Your Ref: OWPC2656
Our Ref: AB/130/13/ 16-12-2013
Please ask for:
Mrs A Gardner

7th May 2014

Change of use and extension to create 3no. self contained apartments and 1no. maisonette. This application affects the character and appearance of Arundel Conservation Area
Arden Guest House 4 Queens Lane Arundel

1:500 Block Plan

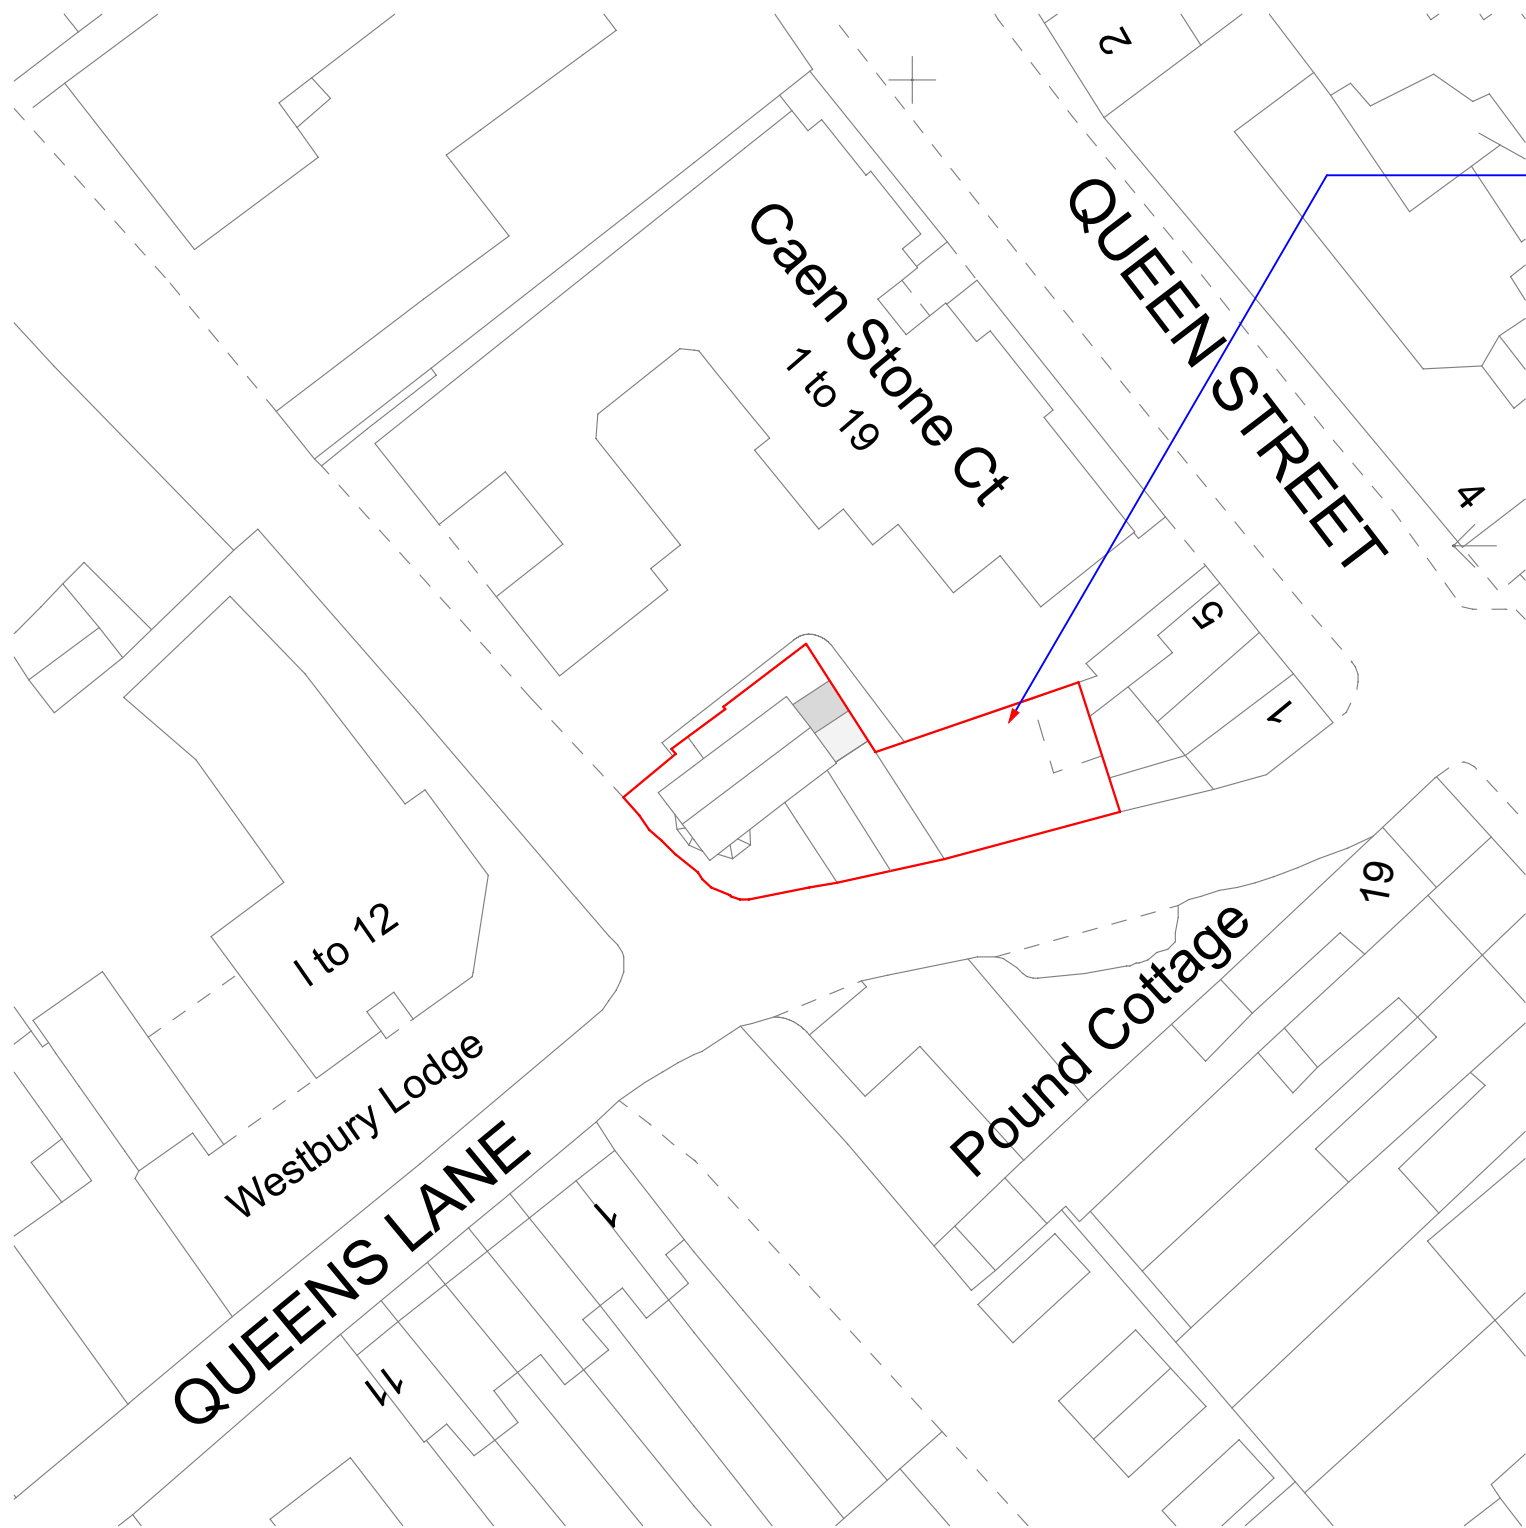
I also require to be assured that access to the courtyard of Caen Stone Court will not be blocked thus preventing movement of vehicles especially emergency service units. I notice there are plans to demolish a concrete garage. Should the structure include any asbestos then I seek confirmation that every effort will be made to prevent the ingress of such dust over my vehicle or the buildings forming part of Caen Stone Court.

Job Title	Arden Guest House	
Client	Mr & Mrs Meathrel	
Drawing Name	Proposed Ground Floor Plan	
Drawing Status	Planning	
Drawn by	DF	Date Dec 13
Checked by		Date
Drawing Scale	1:50 at A2	
Drawing No	Status	Revision
13519/ 05

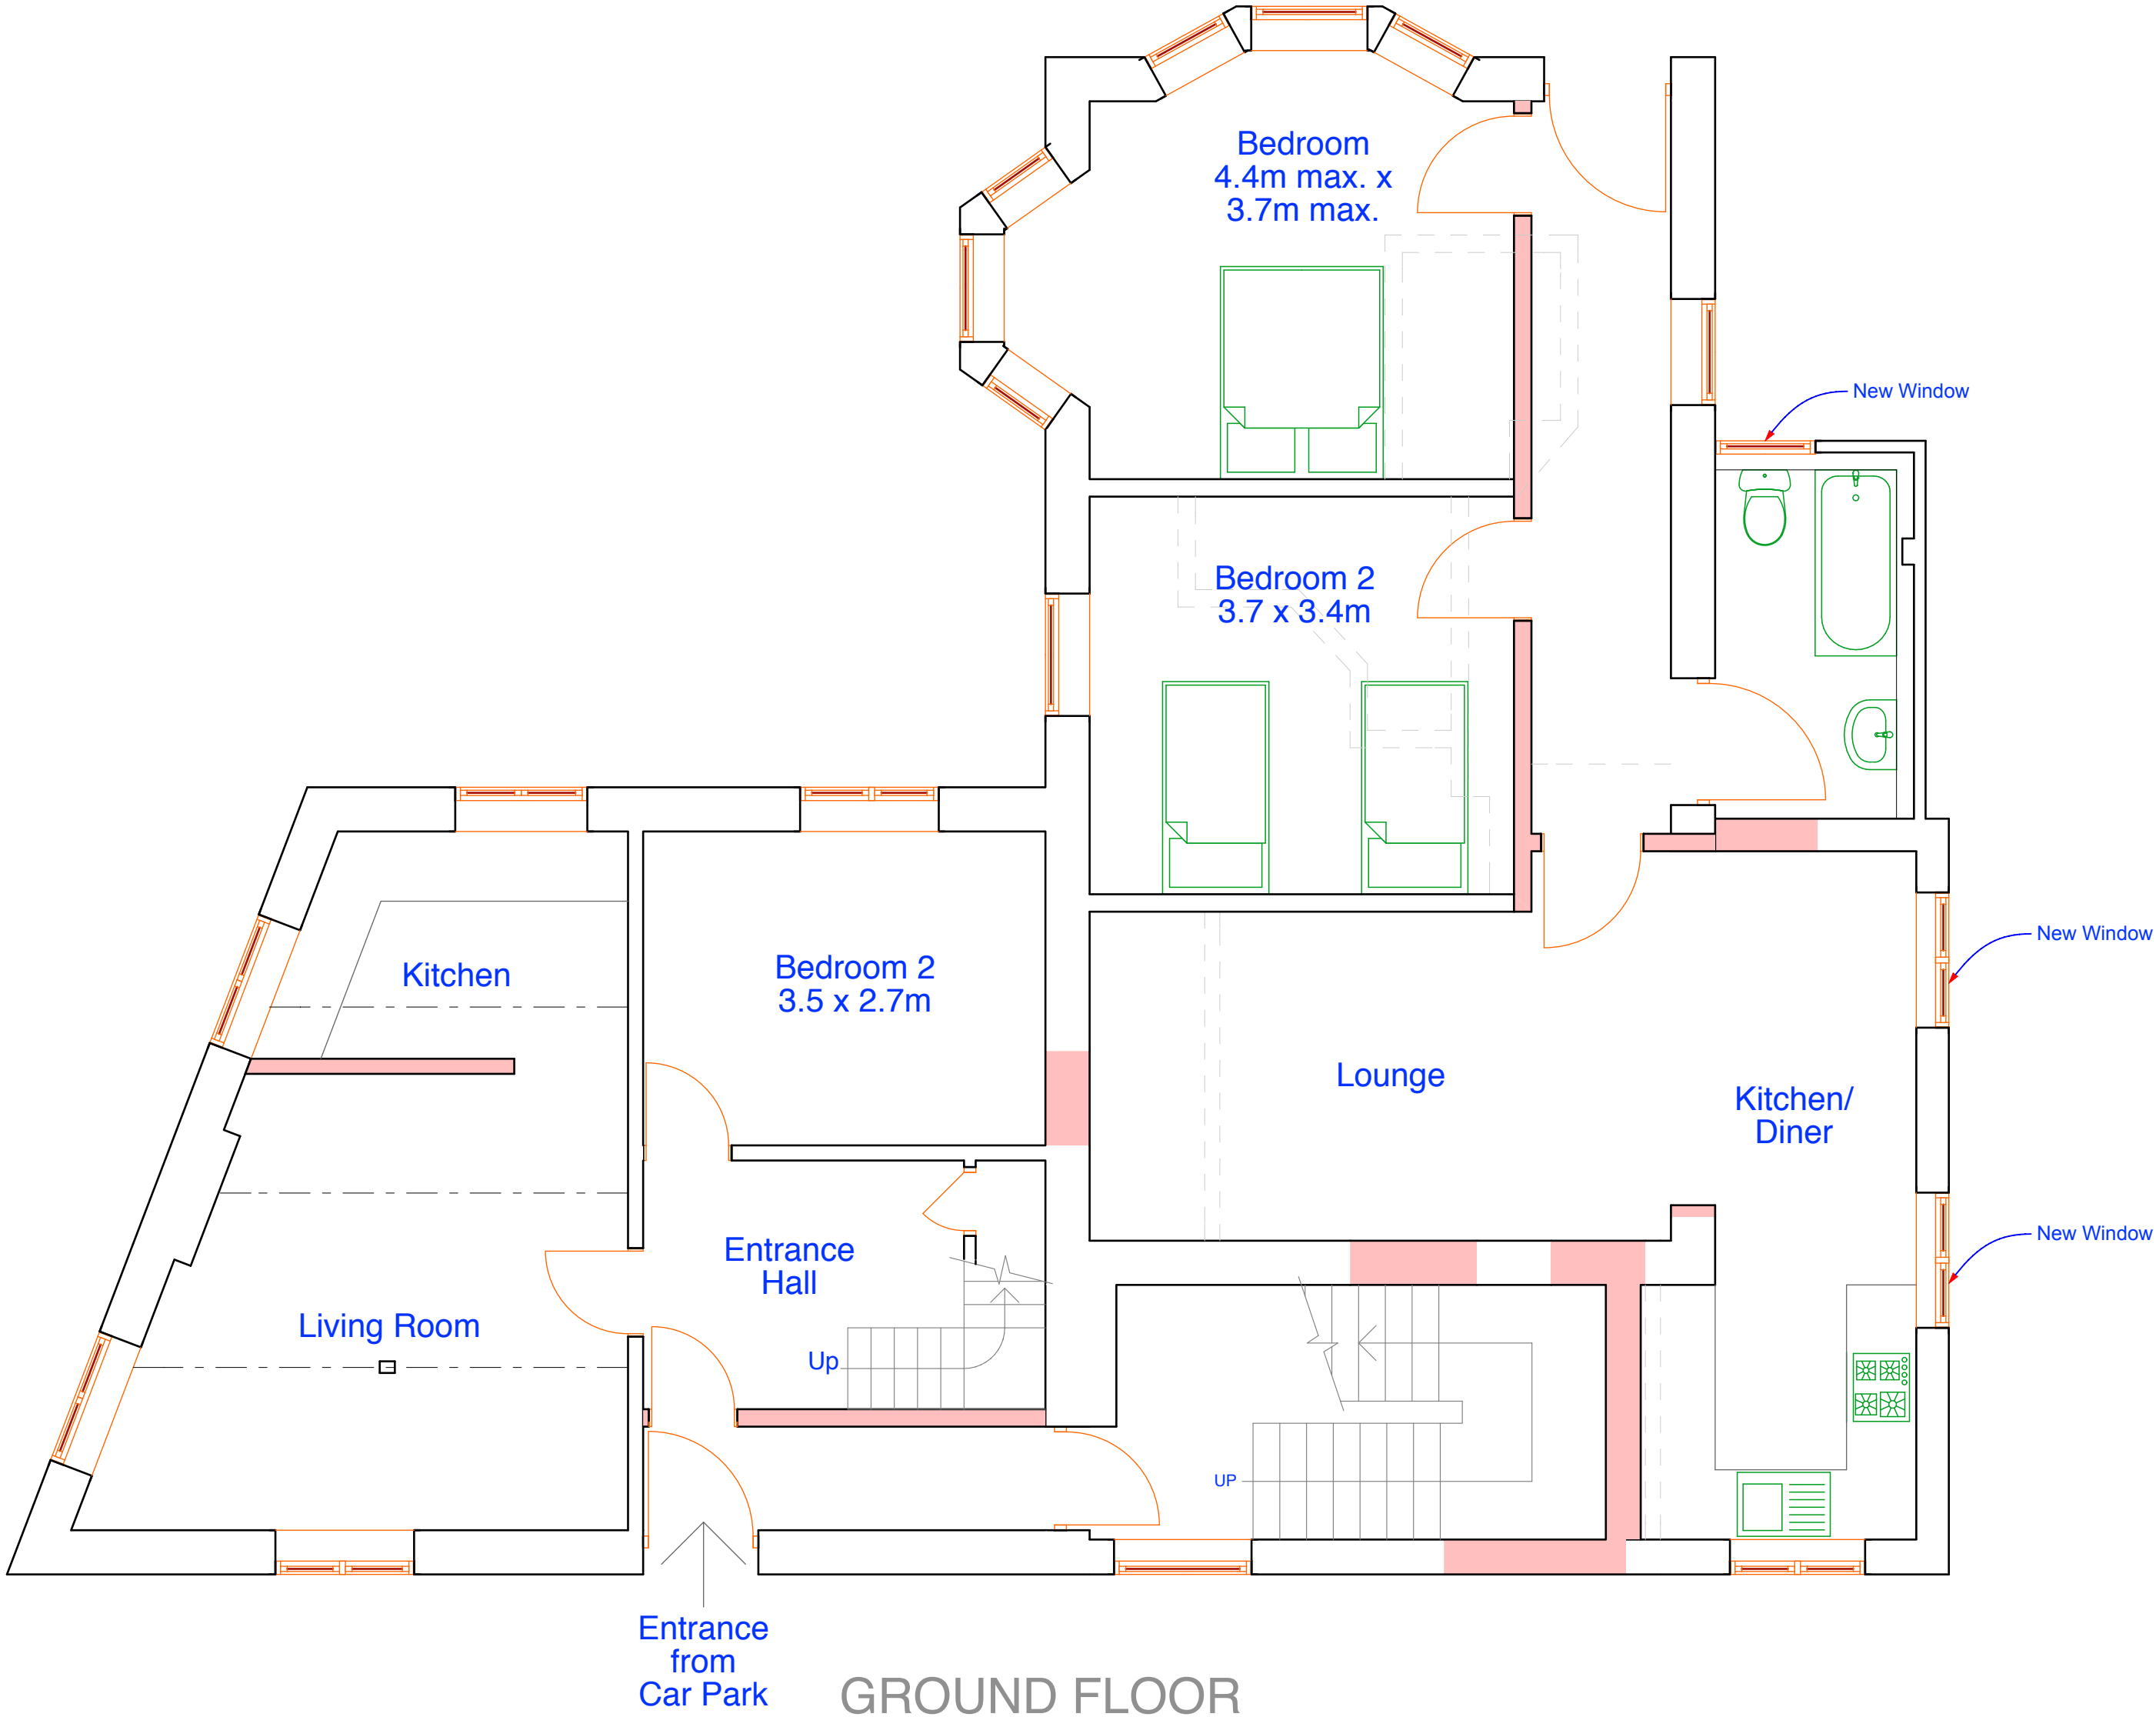
My final comment concerns the proposed parking space for flat 2 at the junction of Queens Lane and Fitzalan. This is a blind, sharp corner which is already restricted by parked vehicles and therefore will create an even greater hazard for road users.
